Reference No:	2026/44/90946/W
Site Address:	J L Brierley, Turnbridge Mills, Quay Street, Huddersfield, HD1 6QT
Description:	Discharge of details reserved by conditions 5 , 6 , 7, 8 (Demolition Works), 9 (new walls/other structures), 14 (electricity substation), 18 (Phase II Intrusive Site Investigation Report), 23 (drainage), 24 (new building retaining walls), 25 (CEMP), 28 (cycles), 30 (evc), 34 (retained walls), 35 (Mitigation Method Statement), 36 (PWMS), 37 (CEMP: Biodiversity), 38 (BEMP), 40 (security and crime prevention measures) on previous permission 2025/91122 for Redevelopment of site for mixed-use E(g) (i, ii and iii) and B8 including: demolition of buildings and re-cladding of southern elevation of retainer adjoining building; retention, conversion and renovation of existing mill/office/workshop/engine house building including alterations; erection of two new buildings; formation of two vehicular access points, service yard and parking areas; and other associated works

DECISION – Discharge of condition – Split decision

Application: 2026/90946

Proposal: Discharge of details reserved by conditions 5 (Building Recording), 6 (Building D Recording), 7 (Demolition Method

PROPOSED FRONT ELEVATION
SCALE: 1:50

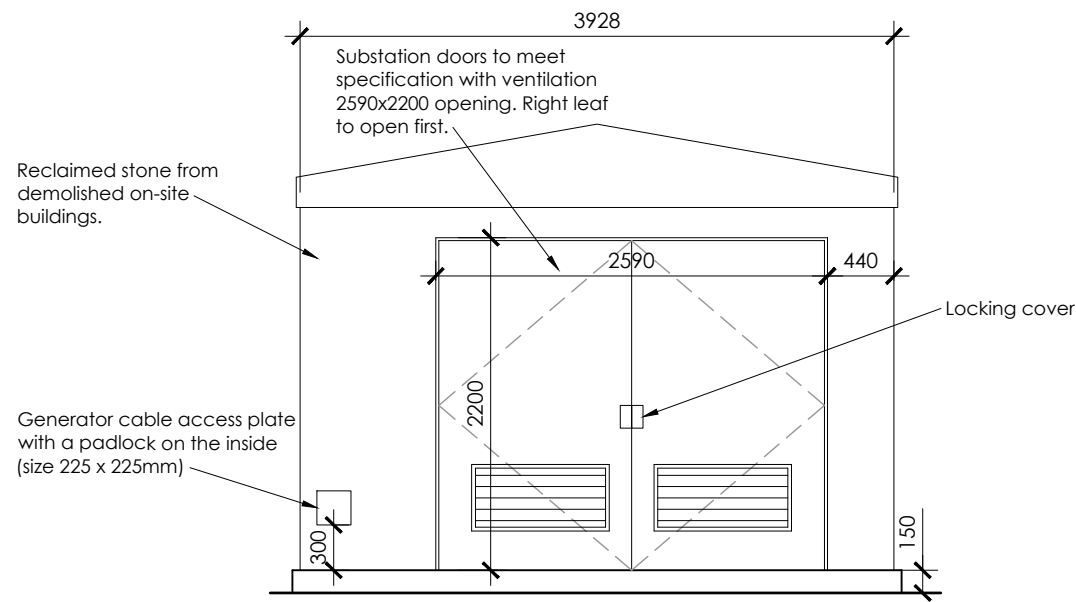
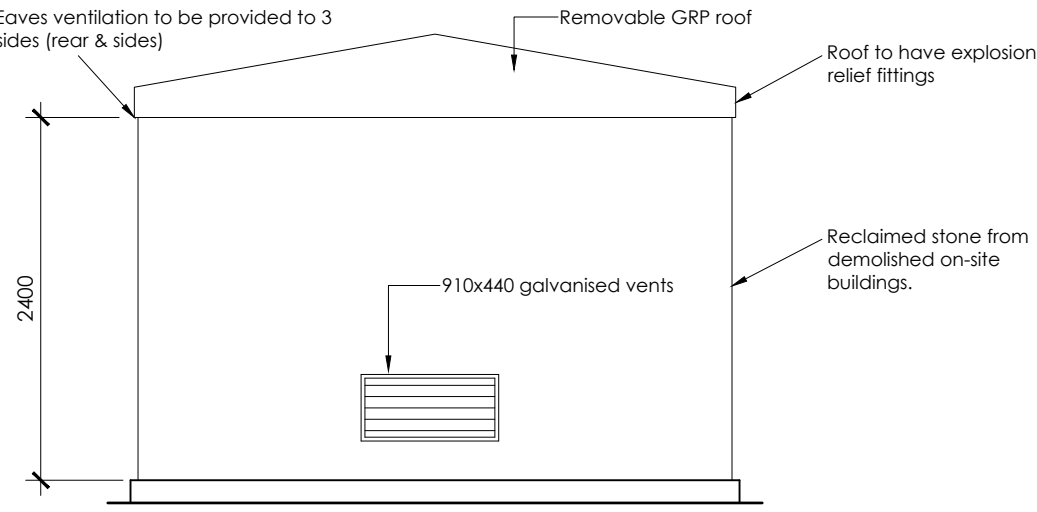
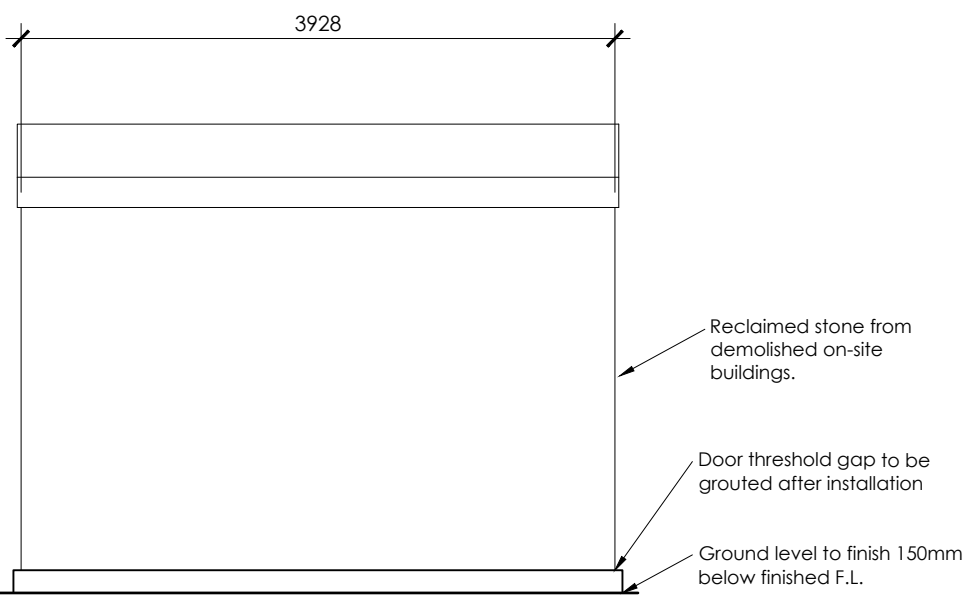
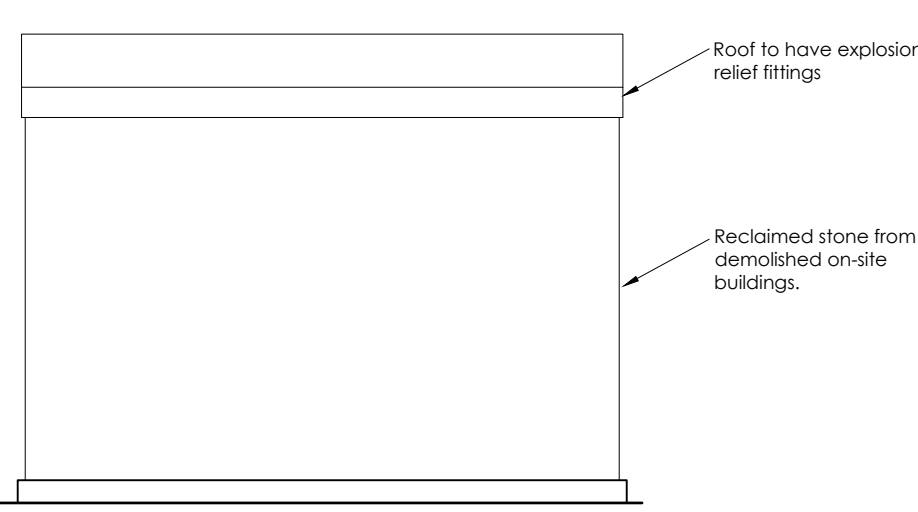
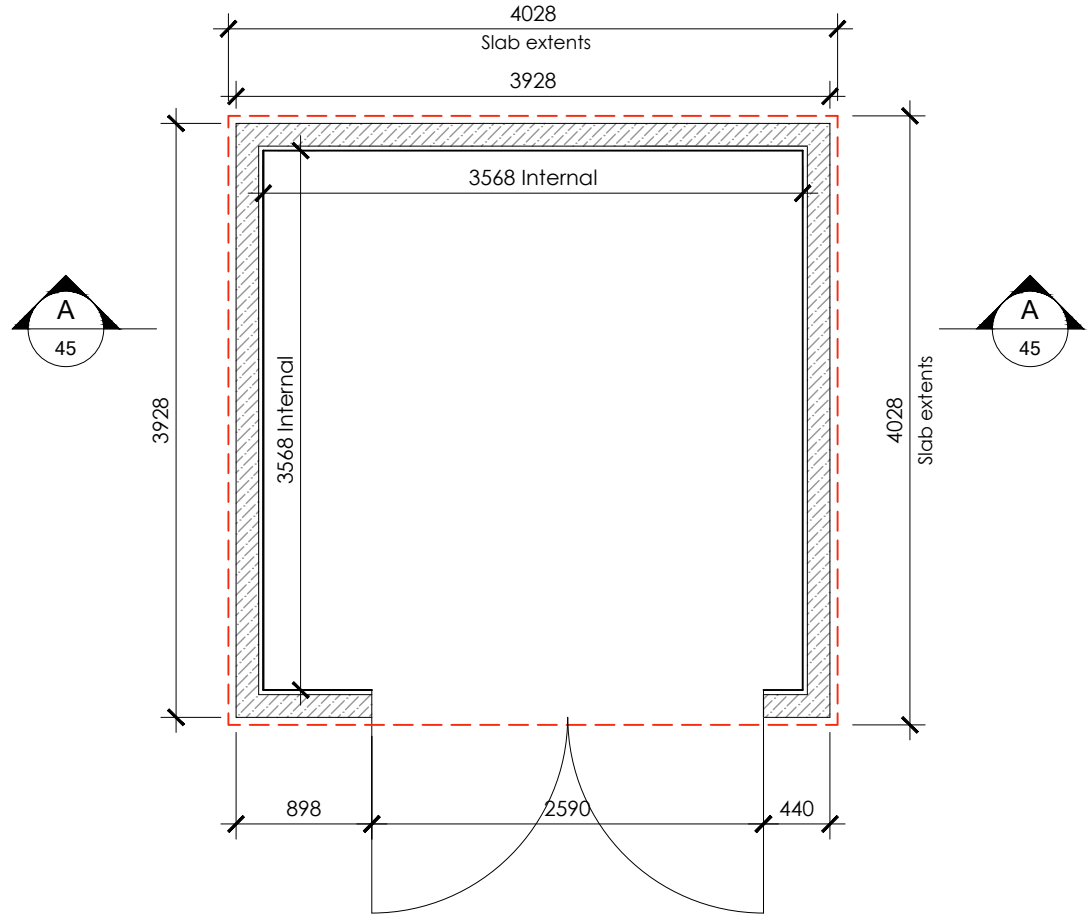
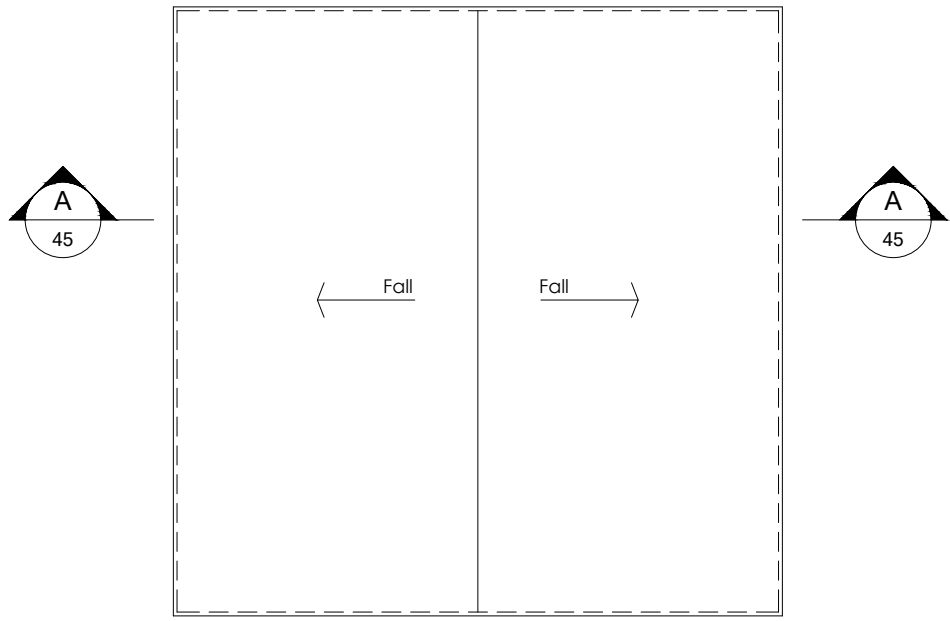
Officers expressed initial concerns over the details proposed specifically seeking confirmation / further details on the walling and roofing material, and colour of the door. The revised submitted information/plan includes comprehensive details of the proposed appearance and external materials of the substation. Officers have reviewed the submitted details which indicates a typical box type, with pitch roof electricity substation, to be constructed in reclaimed stone from demolished on-site buildings and the pitched roof shown to be constructed using GRP Textured - slate effect. While officers expressed a preference for true slate roof, of a steeper pitch, this has been accepted as not feasible due to operational and health and safety grounds, relating to the site's function as a substation. The substation will be located on site in an area appropriate within the context of the site as previously approved on the main planning permission 2025/91122.

The proposed design and use of reclaimed stone from the demolished buildings on site is considered would provide an acceptable appearance when viewed within the site and surrounding area. The submitted details, specifically the plan ref. Sub Station Plans & Elevations ref:3310 45F is considered sufficient to satisfy the requirements of condition 14 and is therefore recommended for discharge. It is not recommended that Electric substation roof materials brochure be included as an approved plan, as it is considered evidence / supporting details to demonstrate that the roofing material, as specified in 3310 45F, is acceptable.
